Sent: 17 March 2026 08:26

Subject: 2025/90889 at location Former Combs Hostel, Hall Lane, Thornhill, Dewsbury, WF12 0PL

Please see ecological commentary below:

Job No.	Drawing No.	Revision
21-105	D01	C
Scales	NTS	
Drawn by	Date	Checked
IAP	22.03.21	NM

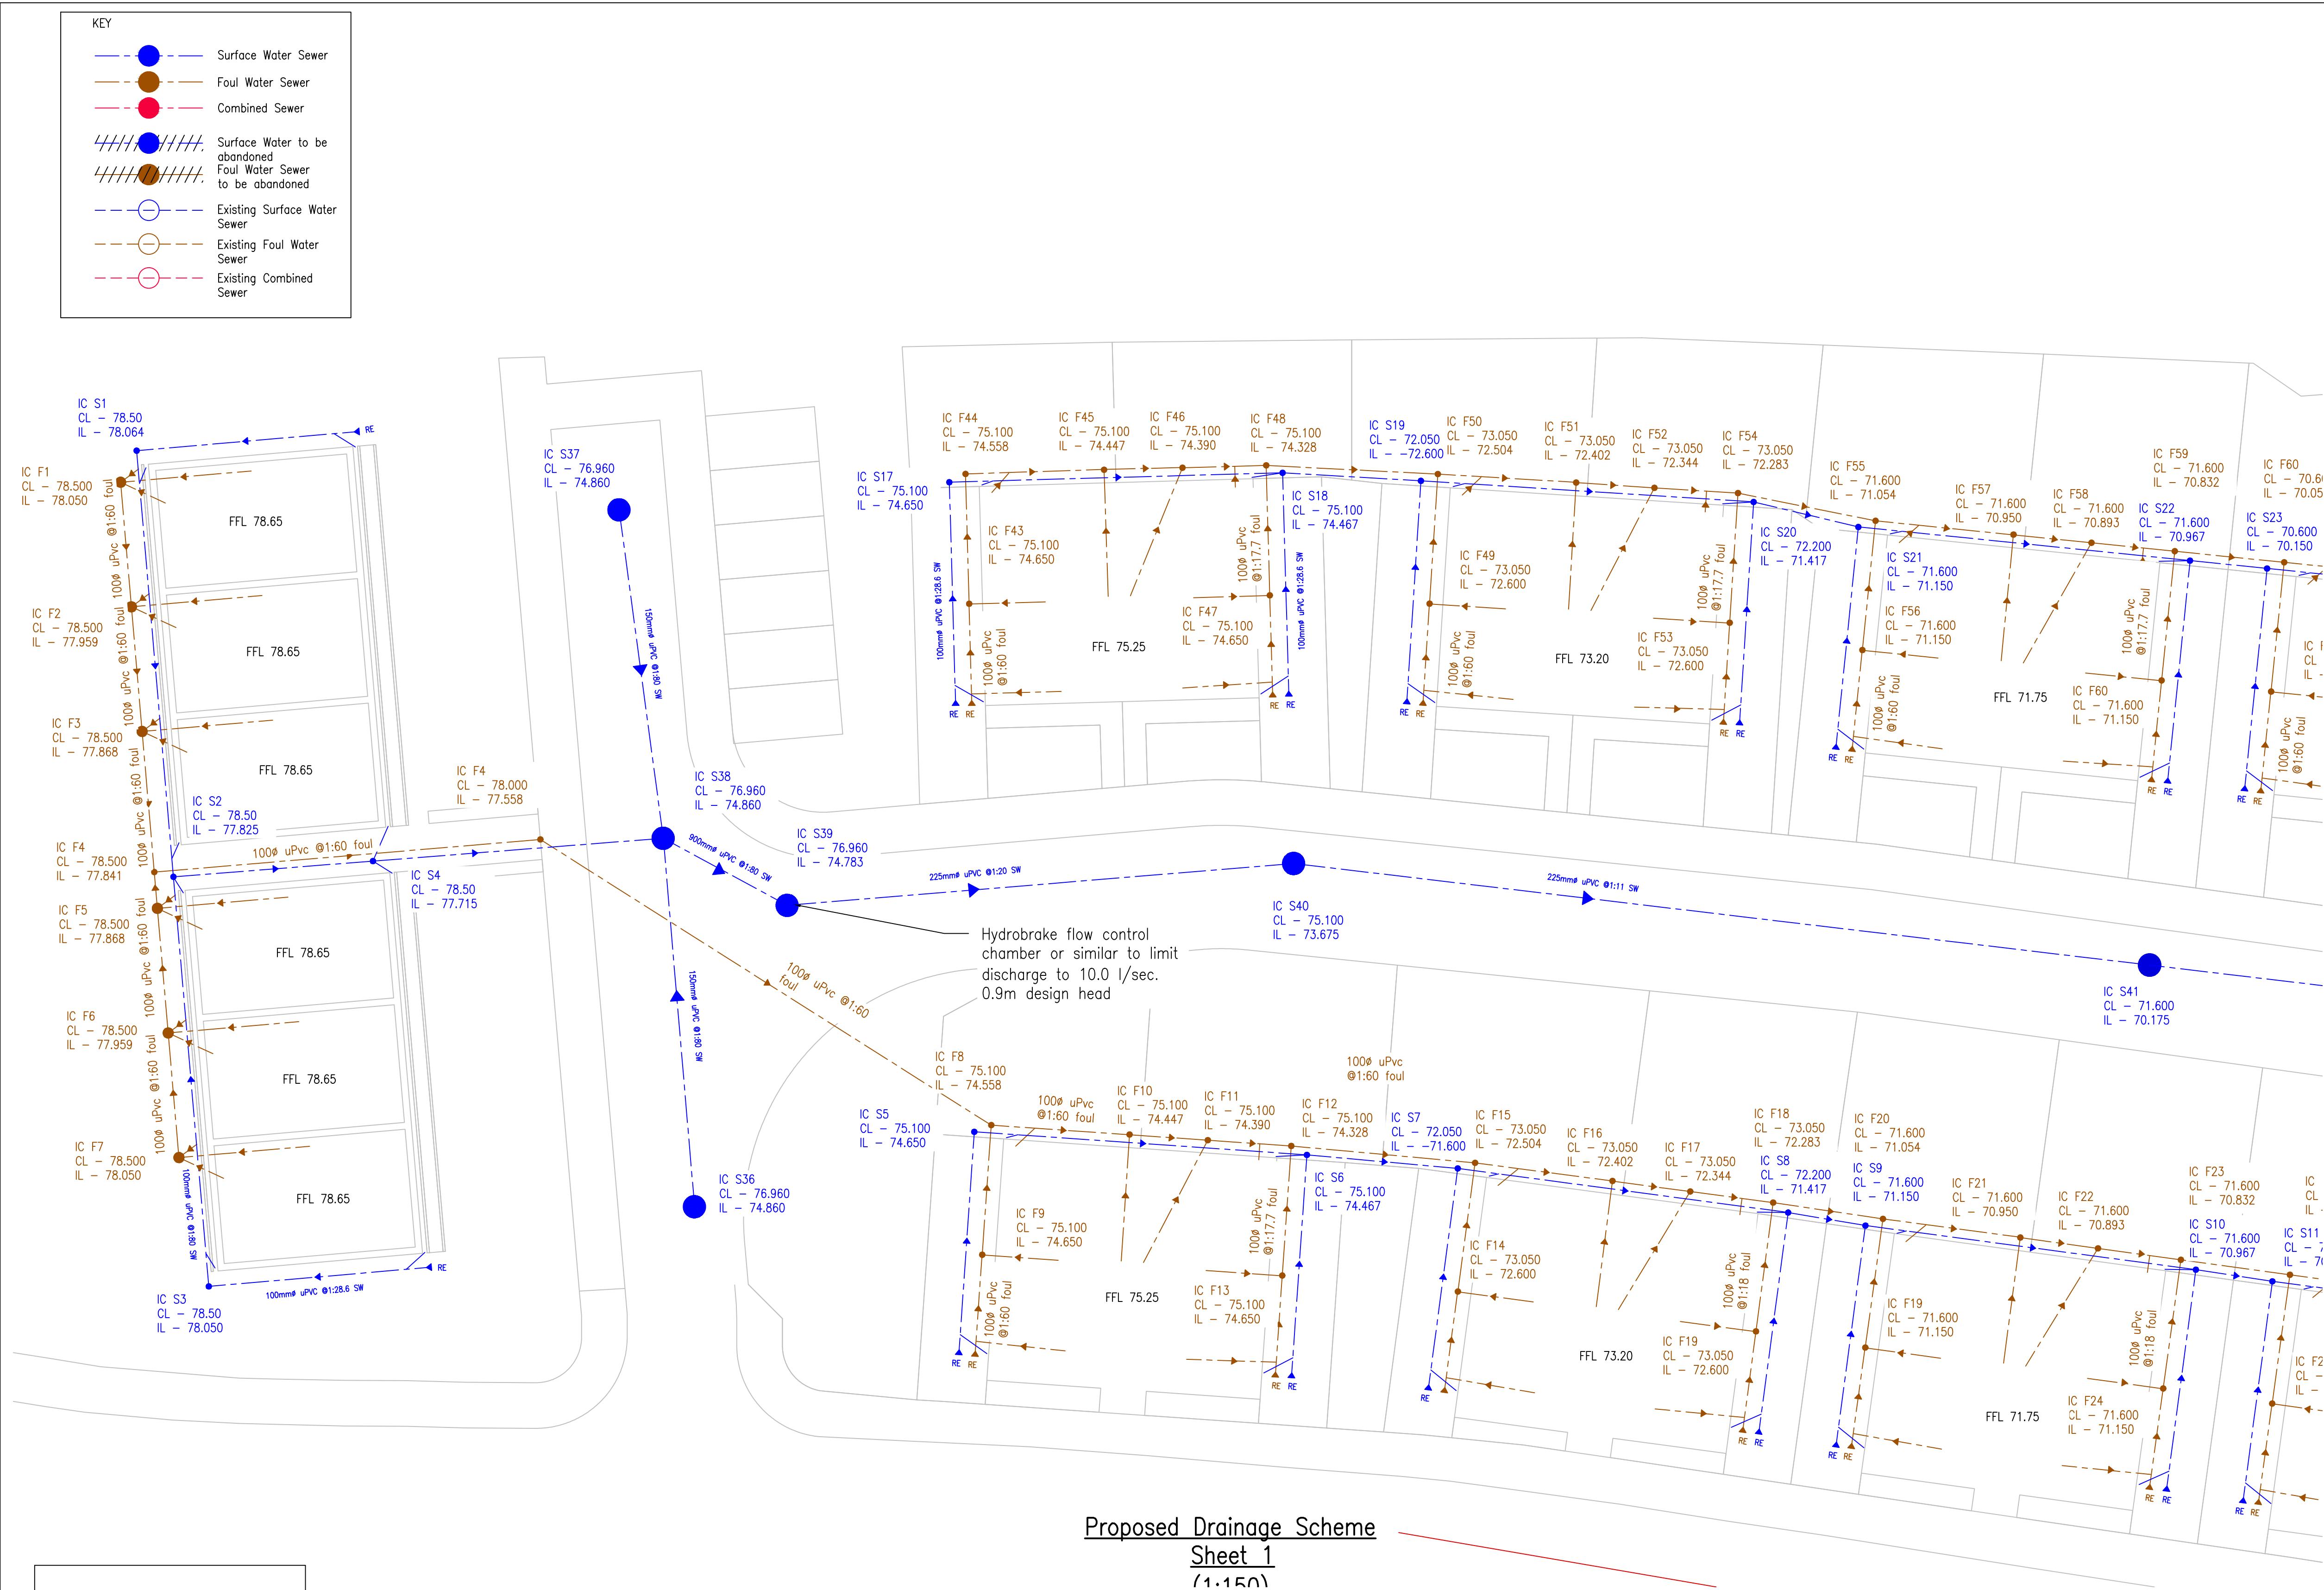
It is recommended that a retention pond / SuDs are considered to (1) encourage biodiversity further (2) reduce risk of run off to nearby watercourses, ponds, and priority woodland habitats. Further information is to be provided by the applicant.
